City of Albuquerque  
Planning Department  
Development Review Division  
P.O. Box 1293  
Albuquerque, New Mexico 87103

## OFFICIAL NOTIFICATION OF DECISION

FILE: Project # 1005482\*  
07EPC-00430 EPC Site Development Plan-  
Building Permit

LEGAL DESCRIPTION: for all or a portion of  
Tracts 2 & 3, **Mira Mesa Estates**, zoned C-2  
(SC), located on HANOVER NW, between 64TH  
ST. NW and 68TH ST. NW, containing  
approximately 5 acres. (J-10) Anna DiMambro,  
Staff Planner

A-100

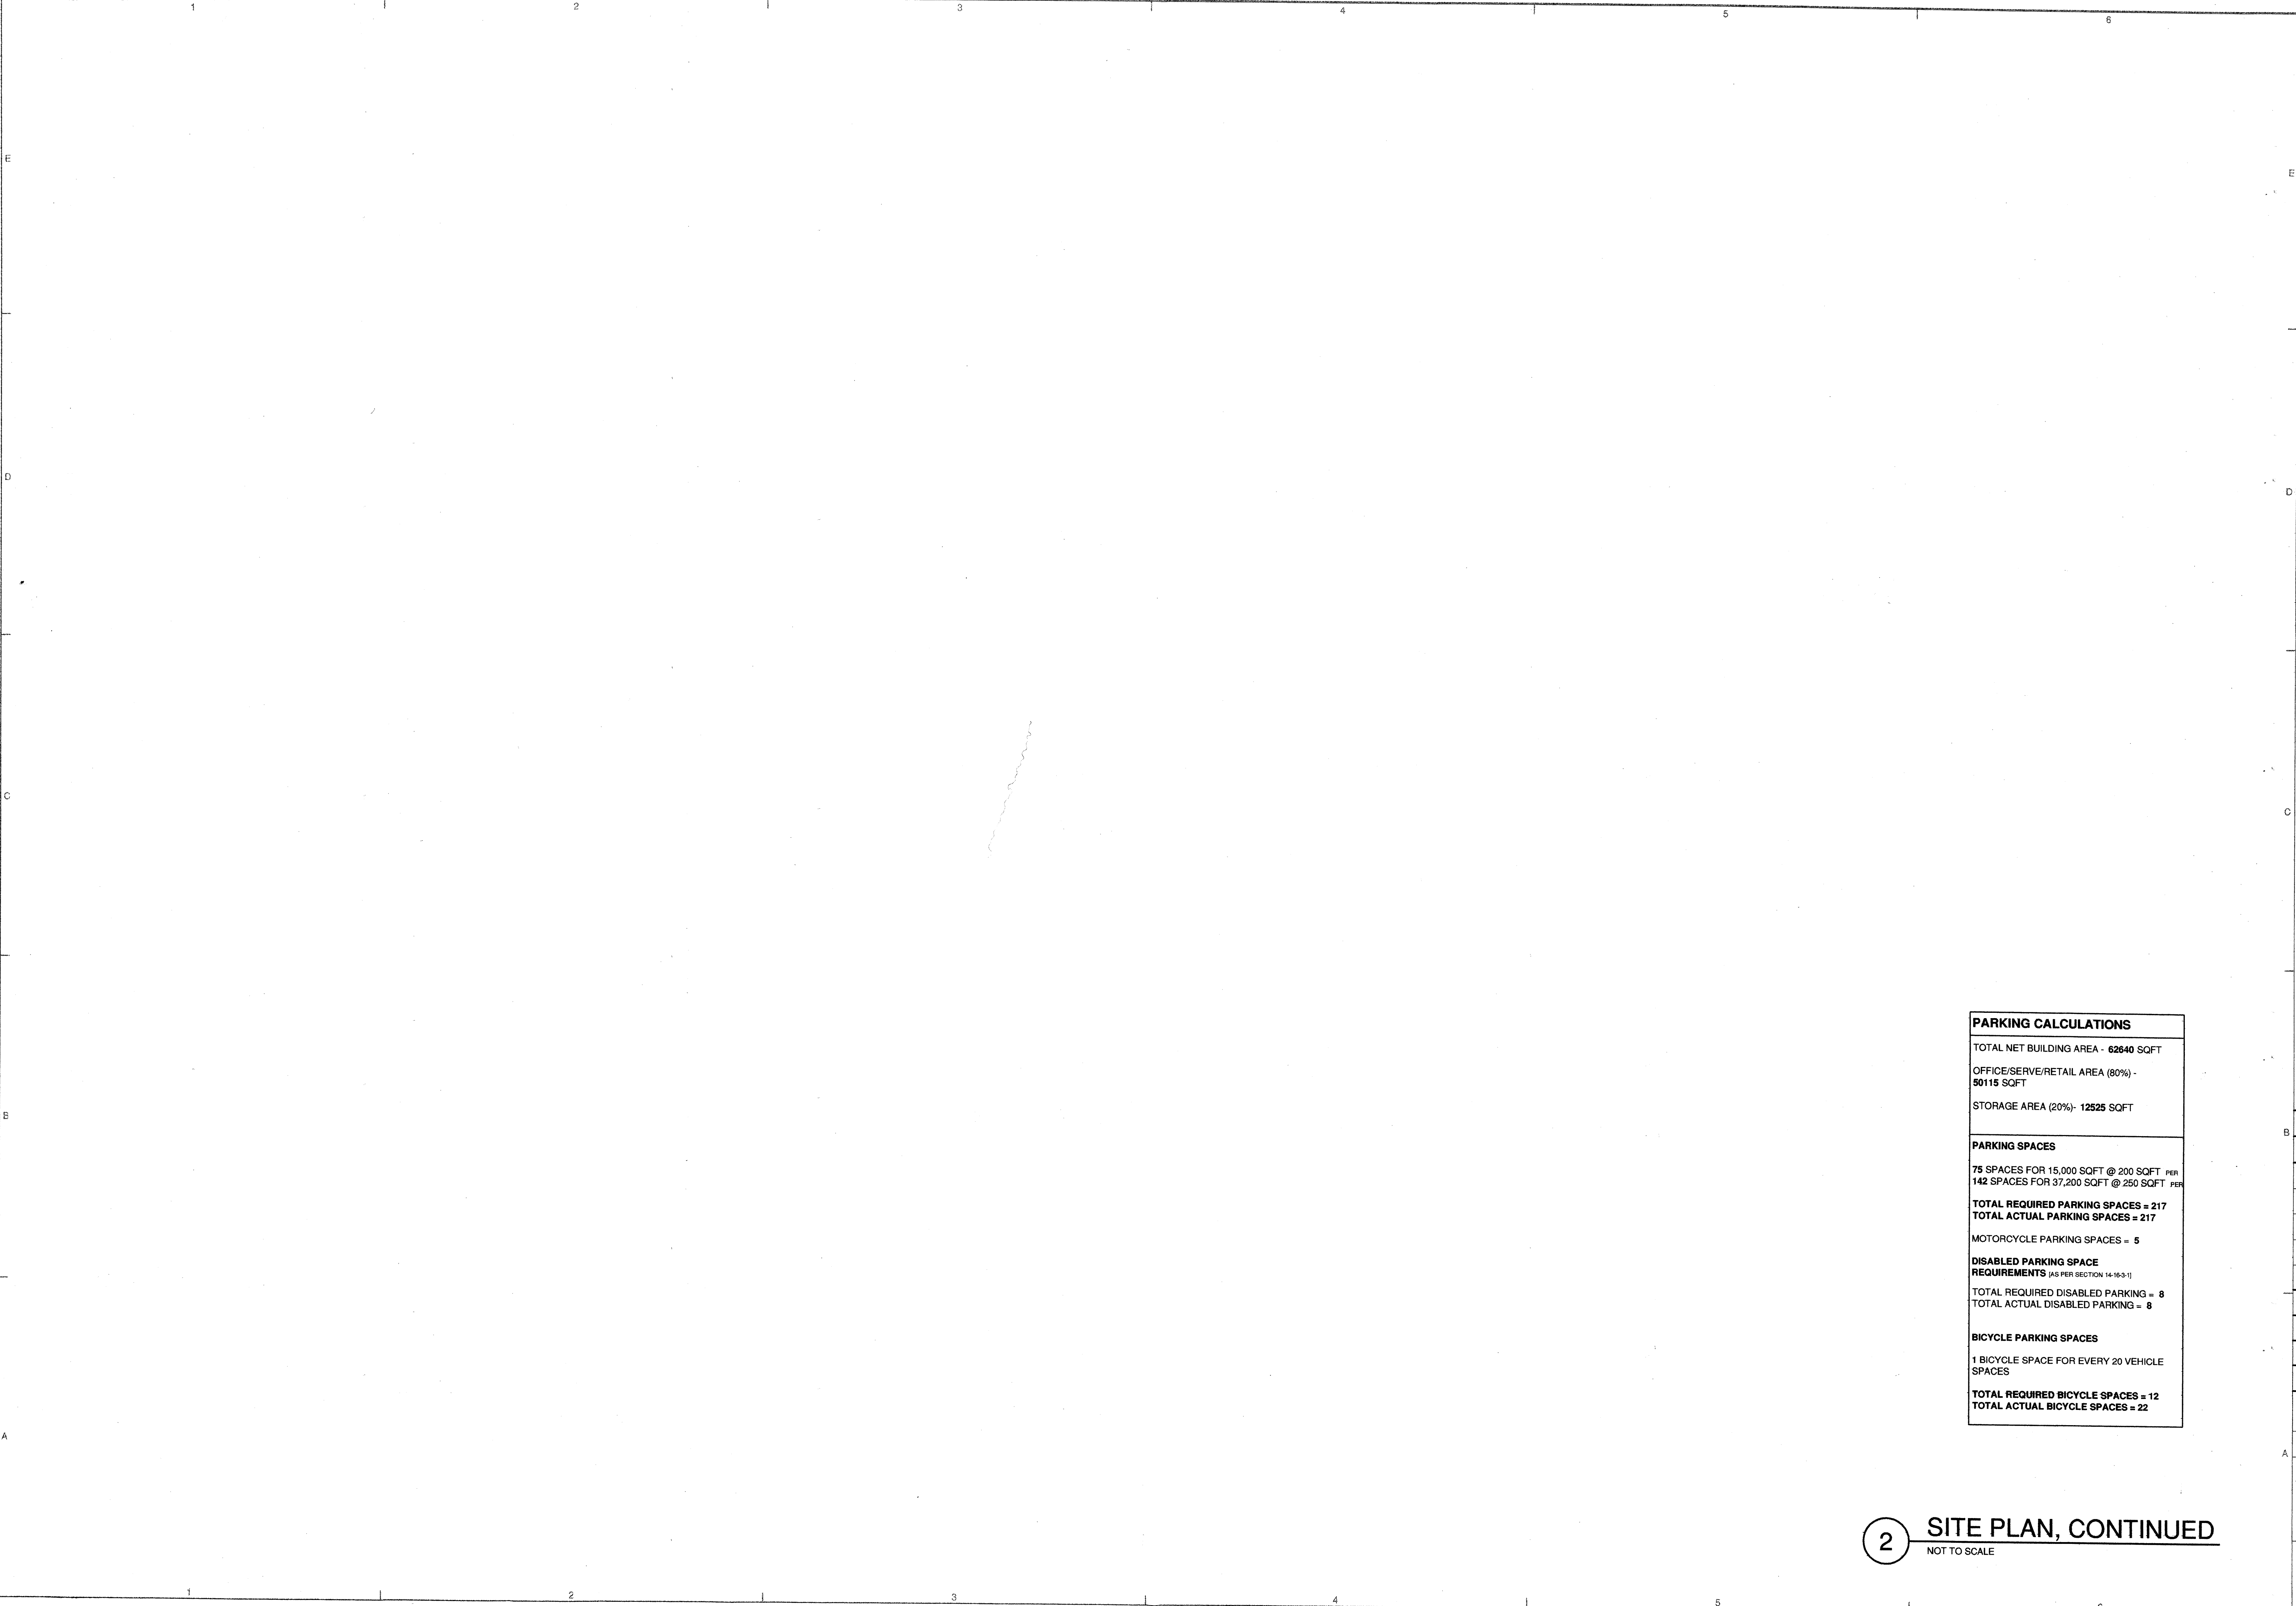
- d. As shown on the site plan, delete one-way markings and signing of main site drives and drive aisles as parking is perpendicular and drive aisles are 24' wide (typical for two-way operation). If one-way operation is desired, then drive aisles should be 22' maximum and parking should be self enforcing angled parking (see DPM).

- e. Delete parking spaces adjacent to and at rear of buildings on south side of site. 20' minimum clear distance to be maintained at all times for one-way operation, fire and solid waste access. Sign and provide pavement markings delineating one-way drive aisle.

- f. Provide truck turning radius information for delivery areas at overhead doors (i.e. turning templates, for design vehicles, on site plan).
  - g. Drives on opposite sides of the street need to be offset at least 50' or centerlines need to be within 15' of each other. May be adjusted, if affected drives are exit or enter only (check with Traffic Engineer).

6. Pedestrian amenities:
- a. Relocate public outdoor space outside to the north end of the parking lot between Business Units 4 and 5.
  - b. Revise square footage calculation of public outdoor space.

- 12. Dumpster number and location shall comply with Solid Waste Management division requirements.
  - 13. Revise Key Note 15 on page A100 to read "Mechanical equipment to be screened by parapet."

6 MONUMENT SIGN
1/2" = 1'-0"

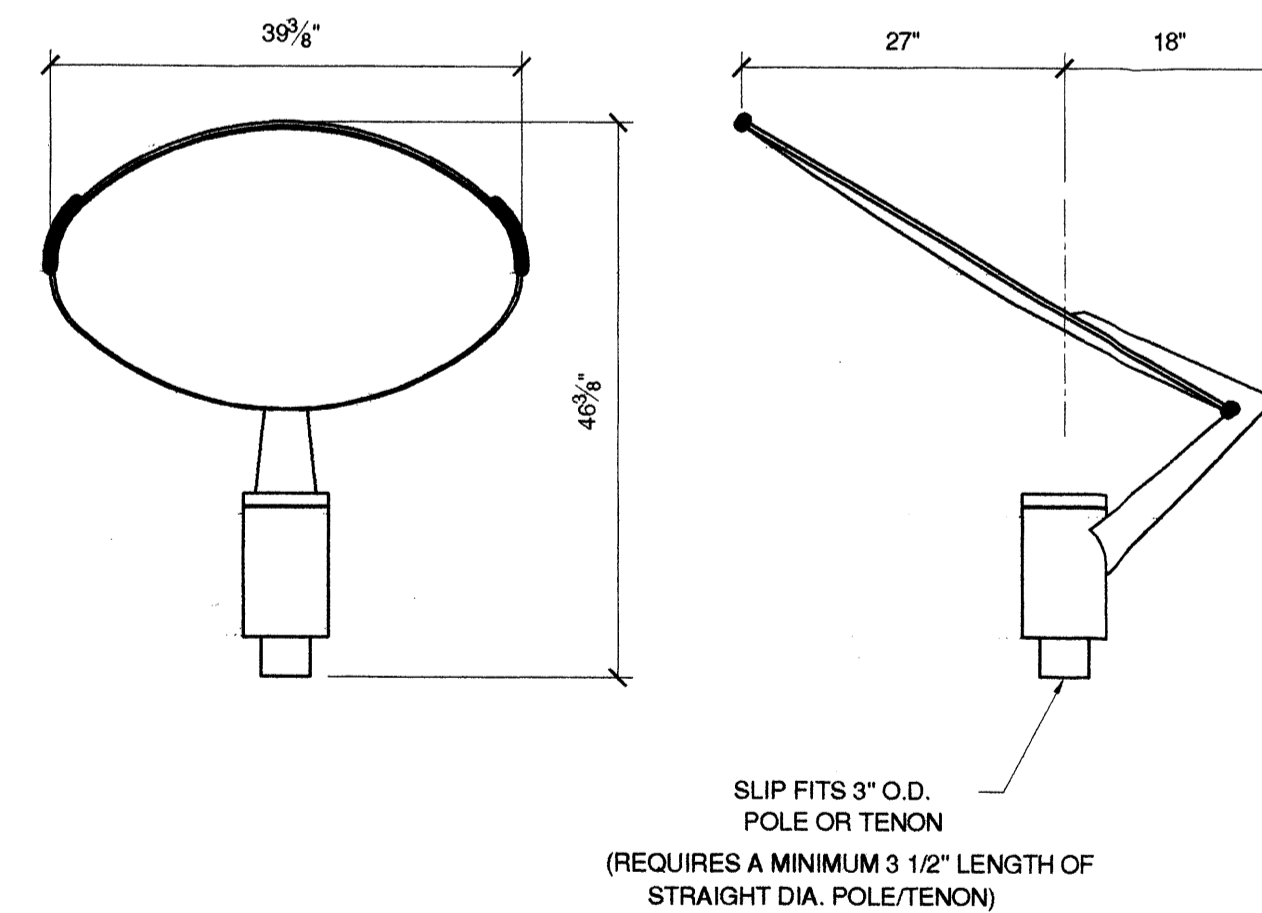
- a. Add a note to the lighting details specifying that all lighting will be in compliance with 14-16-3-9.
    - b. The monument sign shall not be uplit. The applicant shall use sign lighting that meets the intent of the New Mexico Night Sky Protection Act.

SHEET TITLE
L100
SHEET ___ OF ___

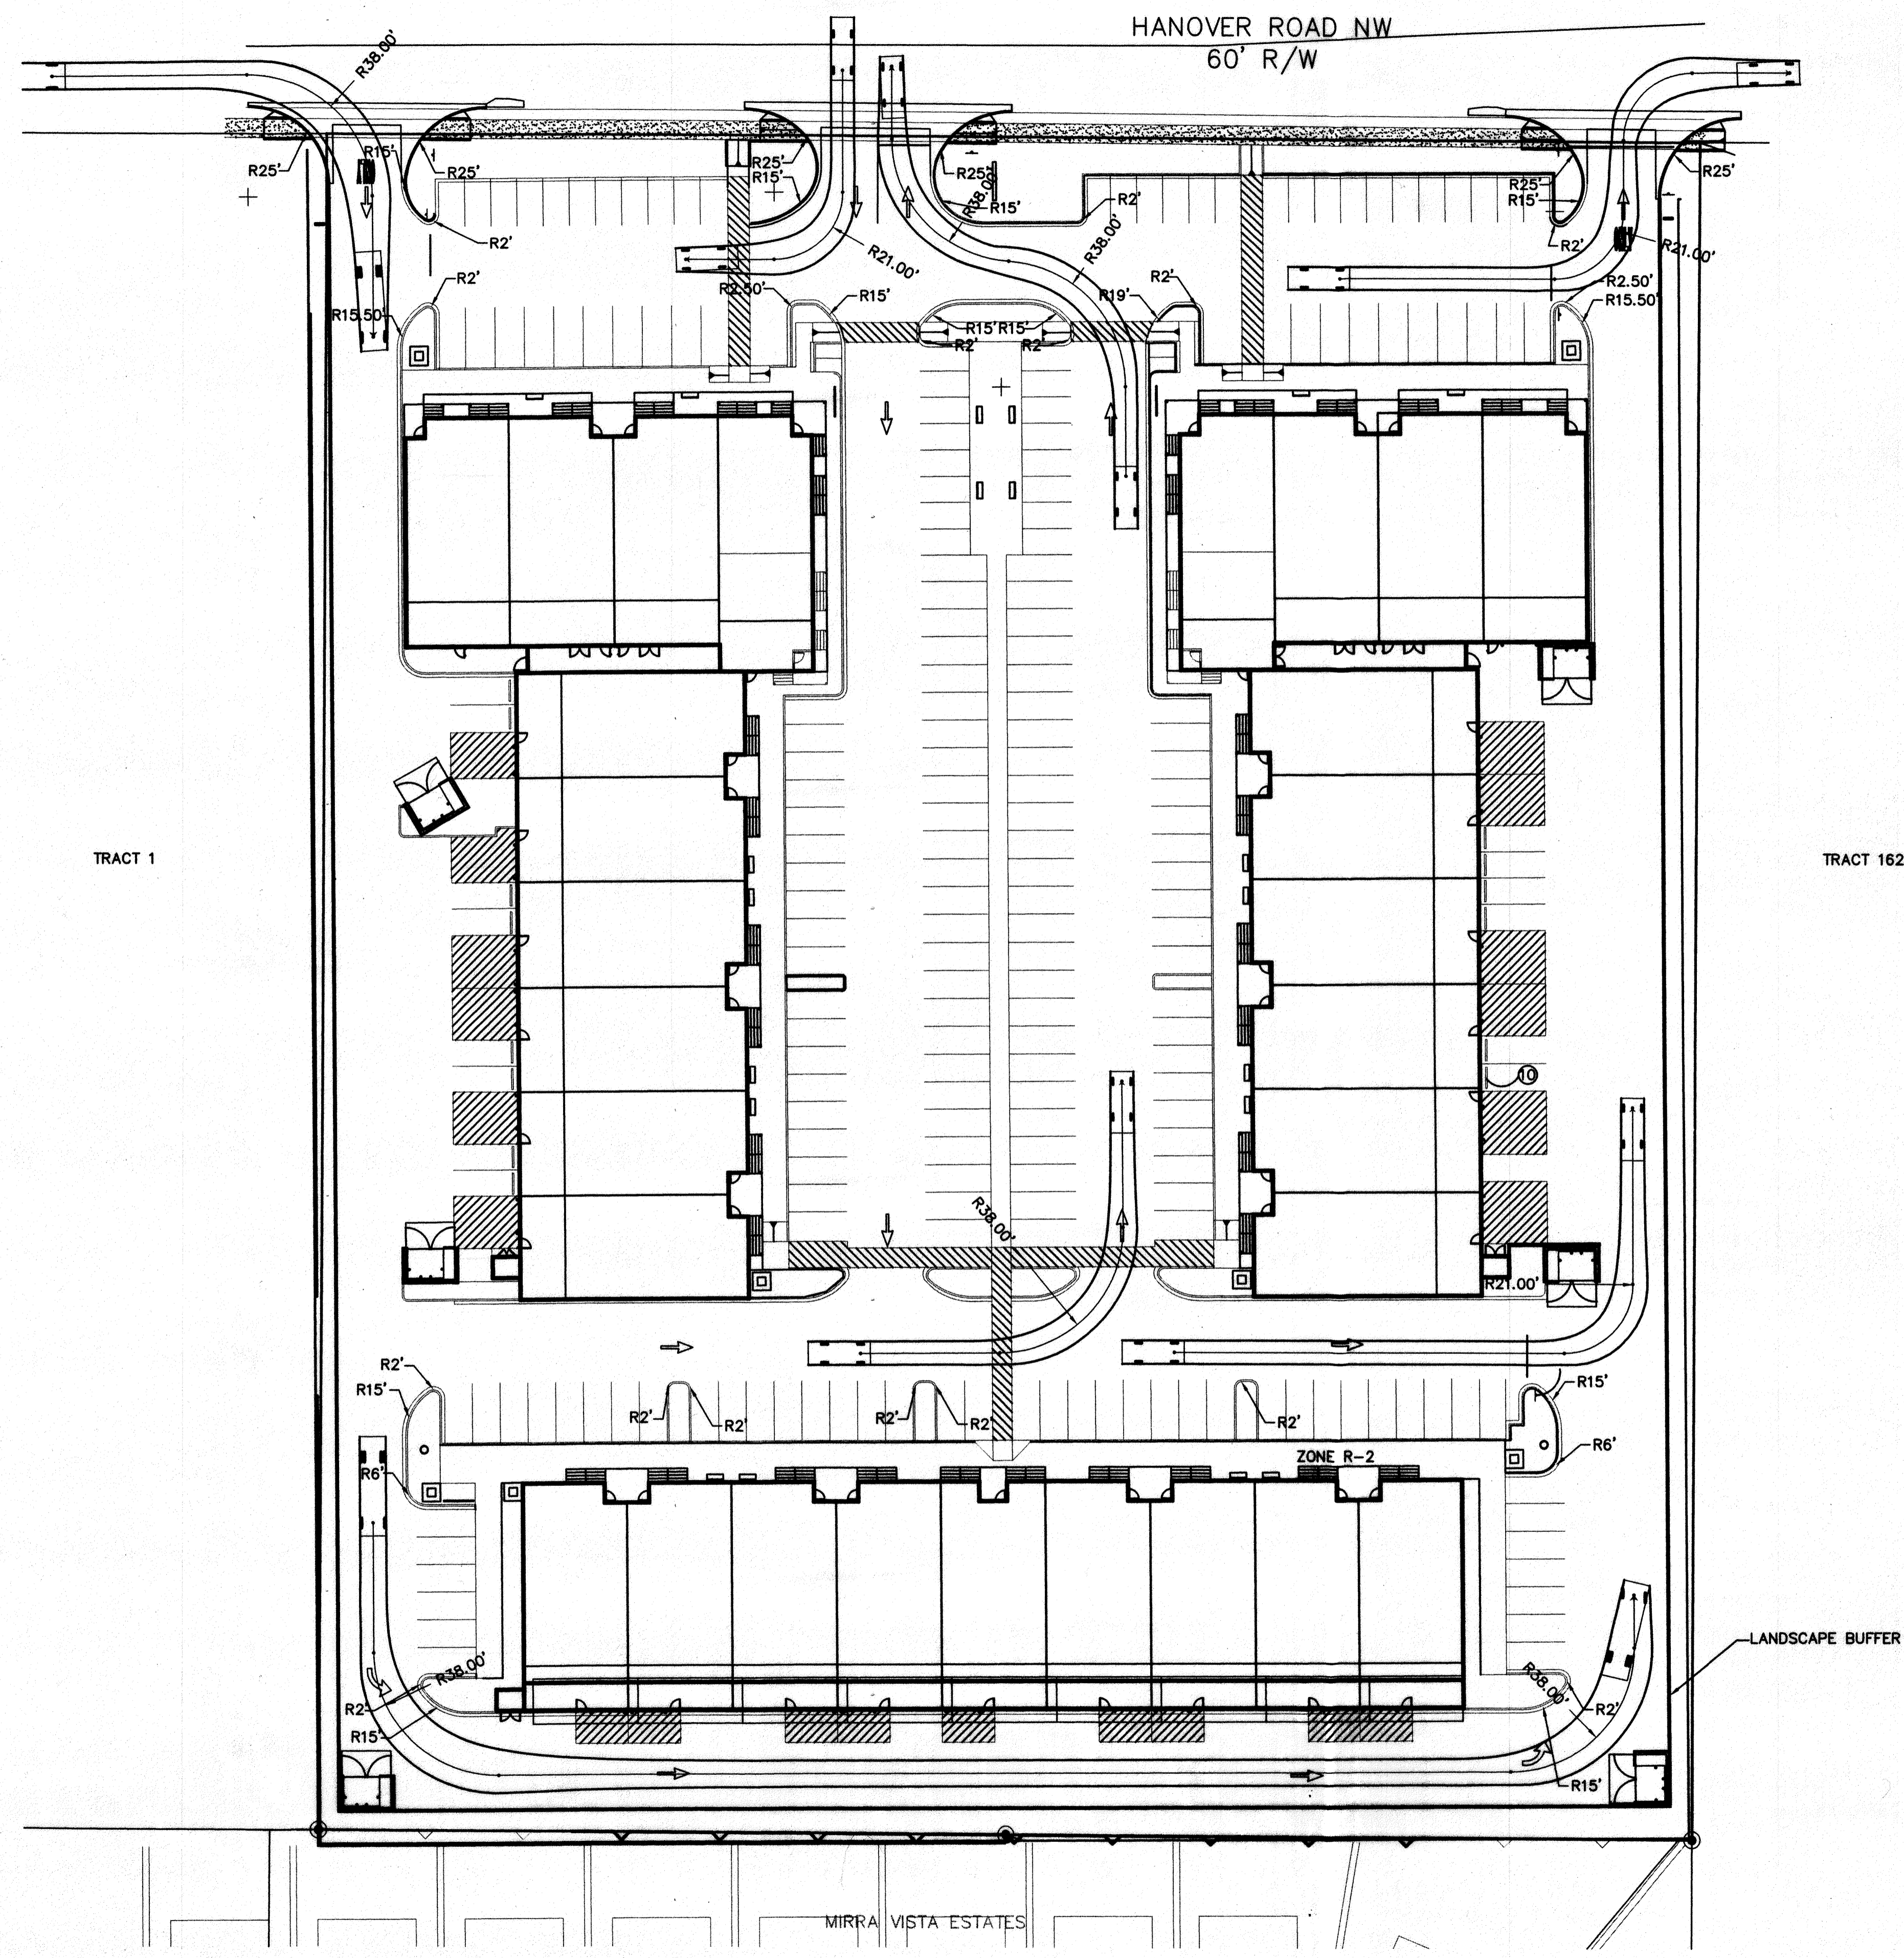
- b. Use proper form of the word "than" in the last Note on page L100.
    - c. The number of parking spaces provided shall be revised on page L100.
